From: Nia Russell [REDACTED]
Sent: 14 September 2017 19:45
To: Michael Eastham
Cc: Arfon Hughes
Subject: BE/102/17/OUT - SALTBOX - response to Bersted Parish Council Objection

From: Charlotte Hardy
Sent: 23 August 2017 17:46
To: Michael Eastham
Subject: Flood Risk Assessment for BE/102/17/OUT

**Hybrid Planning Application for the comprehensive redevelopment of the Salt Box site,
Bognor Regis (Ref: BE/102/17/OUT)**

Table 1: Flood Zones Map (Present Day) with Enterprise Bognor Regis Parcels Illustrated.

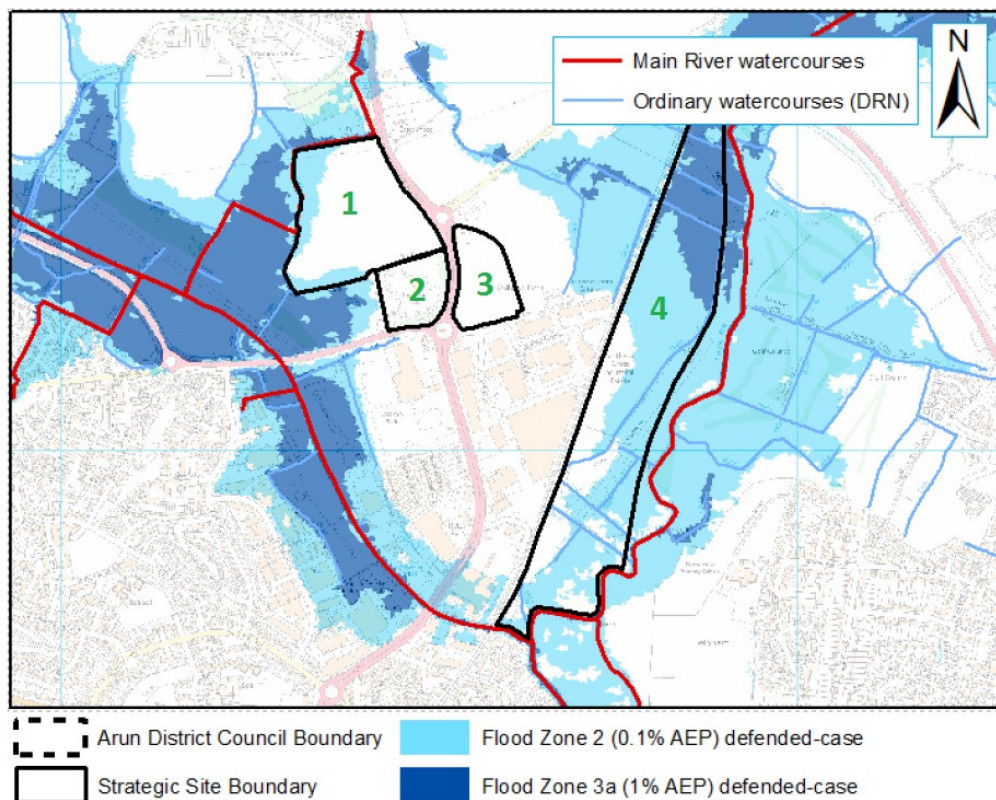
1. There is no mention in the Local Planning Policy section about the updated SFRA from last year or anything in terms of the Main Modification version of the Local Plan, which includes number of revisions. Importantly Appendix J of this includes site summaries for all the locations that were being considered for inclusion in the Main Modifications, including Bognor Enterprise. In particular, responding to a question from the new Inspector there is an additional bullet point that we are inserting into SD SP1a Strategic Approach, specifically covering the need to take account of the coastal topography and incorporation of adaptations to deal with climate change particularly in high risk flood areas. This is MM5 in ADCED49 on our Local Plan Examination Page.

2. Again importantly there was an updated Sequential and Exception Test issued alongside the Main Mods consultation earlier this year that again seems to have been missed. Critically at the bottom of page 8 of their submitted FRA they mention that an exception test is not required. Due to the fact that we covered the location as a whole in the sequential test. Though there is a lower risk for this site the northern and western boundaries are partially covered by the higher risk extents and the site summary information shows that this increases when the impact of climate change is considered.

3. Much more detailed information relating to this location is again contained within the Strategic Surface Water Study (SSWMS) that was done to inform the Main Modifications. This crucially in Stage 2 it included calculations in terms of impermeable areas and the changes to the quantities of surface water. It discusses and proposes appropriate on-site and off-site solutions. Appendix B and C however include information/suggestions discussed at the workshop of that stage and in Appendix C concept plans with a potential fluvial flood compensation area identified off site to the north.

4. Finally just so you aware but the national maps were updated around March this year with the new Emsworth to Littlehampton model. It is unclear from their statement as to what modelling they requested from the Environment Agency.
The Extract that they have included relating to the peak river flows is incorrect. The one of relevance to this is below, where you will see that the figures are significantly above those contained in their FRA. The higher central figures were those that the EA considered to be most appropriate for our strategic work (SFRA Update 2016) but did mention that at application level they would expect that something should at least briefly cover the others. I will of course leave this aspect for EA to comment on.

Maybe the easiest thing is if they revise the FRA so that it makes mention of the newer evidence, plus mentions what (the attenuation ponds) have been incorporated into the masterplan. If it weren't for the inclusion of the masterplan there would be nothing in the text referring to the potential solutions. They definitely need to do a revision as they are stating that there is no issue of fluvial flooding after mentioning the proximity of rife and of Shripney Manor Ditch. The second of these runs along the majority of the western boundary and some of the northern boundary (this can clearly be seen on page 11 of the [part 1 of Appendix B to the SFRA Update](#)), as well as explicitly mentioned in the site summary for the location and the SSWMS.
